From: Laura Gibbons <Laura.Gibbons@arun.gov.uk>
Sent: 22 May 2019 15:54
To: Simon Davis <Simon.Davis@arun.gov.uk>
Subject: RE: Planning Consultation on BE/60/19/DOC 182 Chichester Road

Engineers Comments Regarding Condition 4- surface water drainage

Client
Simon Abbot
Drawing Title
Surface Water Drainage

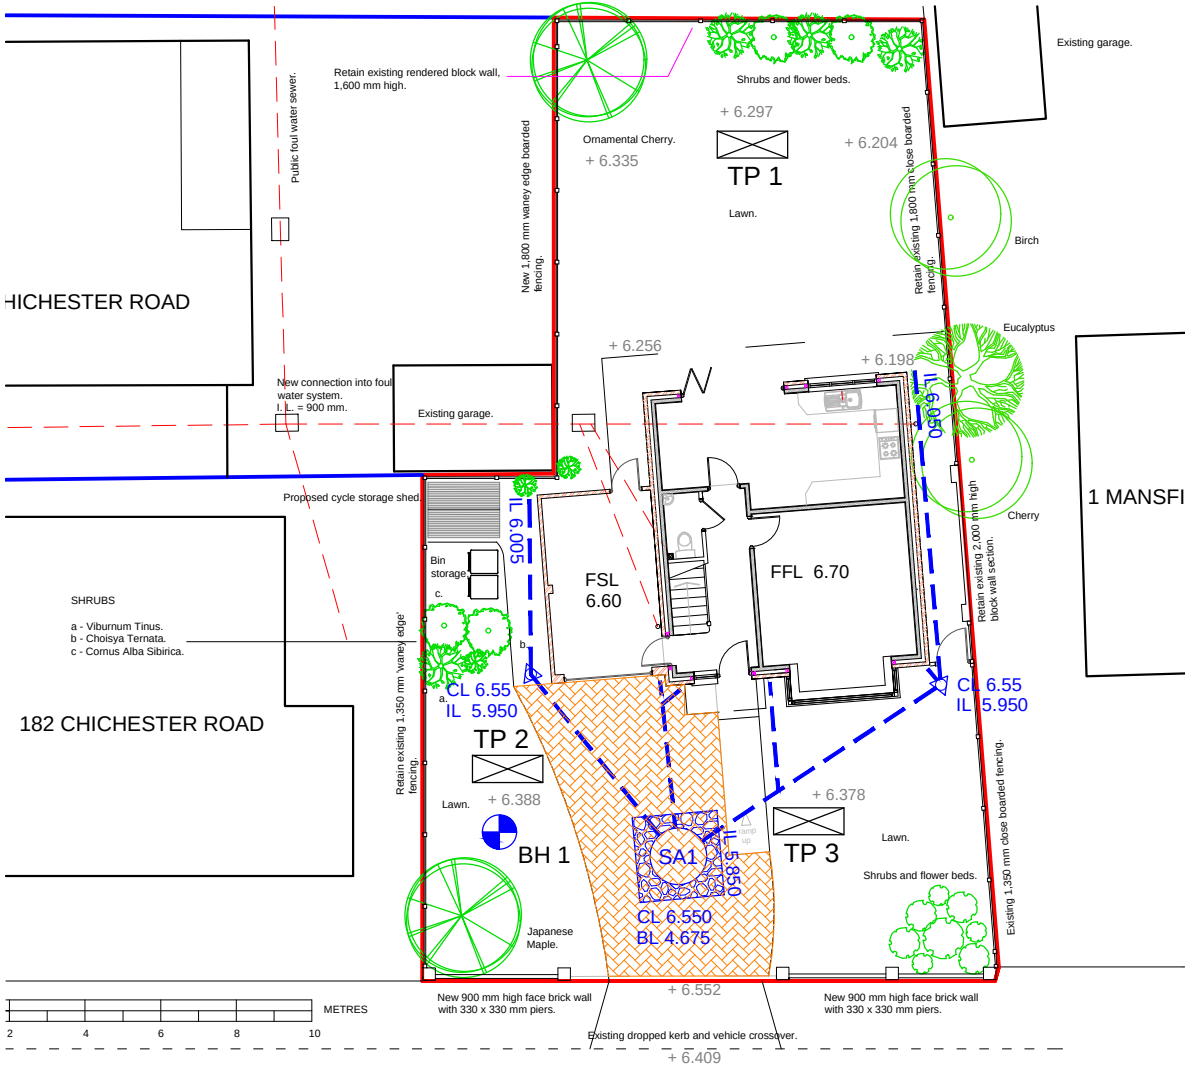
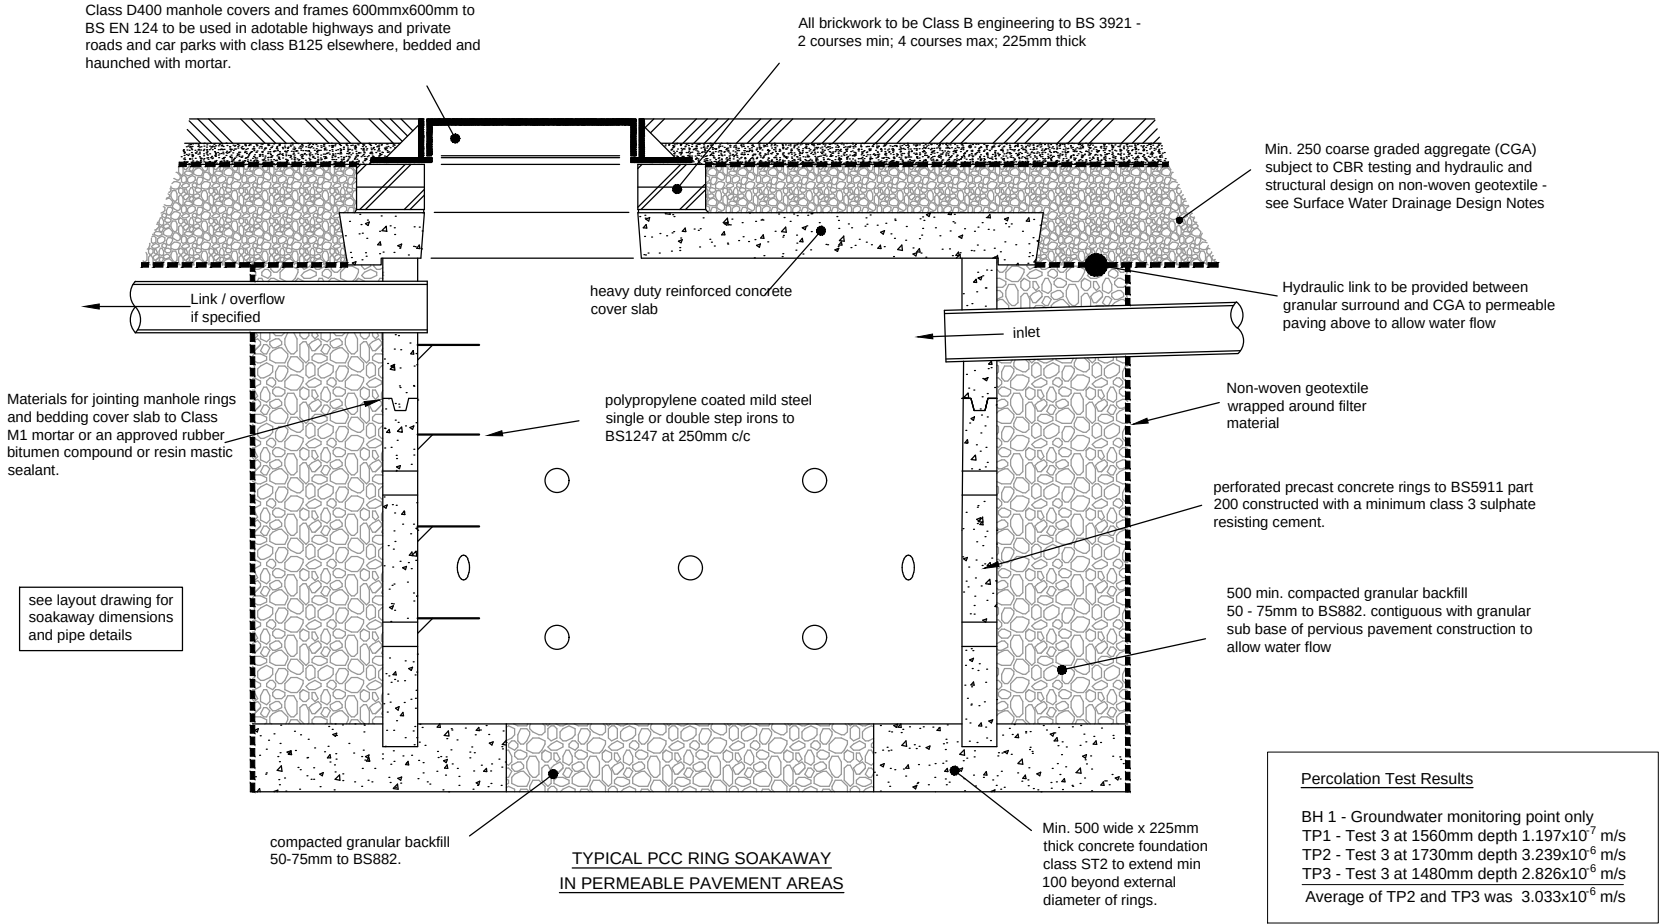
- Average infiltration rates have been used in design. We require worst case results to be used. Please can further detail on the infiltration testing results be submitted, i.e. depths and locations of testing and results.
- It is unclear if winter groundwater monitoring has been completed. Please can the applicant confirm the duration of groundwater monitoring.

- No calculations have been submitted with the application. Please can these be provided.
- Average infiltration rates have been used in design. We require worst case results to be used. Please can further detail on the infiltration testing results be submitted, i.e. depths and locations of testing and results.
- It is unclear if winter groundwater monitoring has been completed. Please can the applicant confirm the duration of groundwater monitoring.
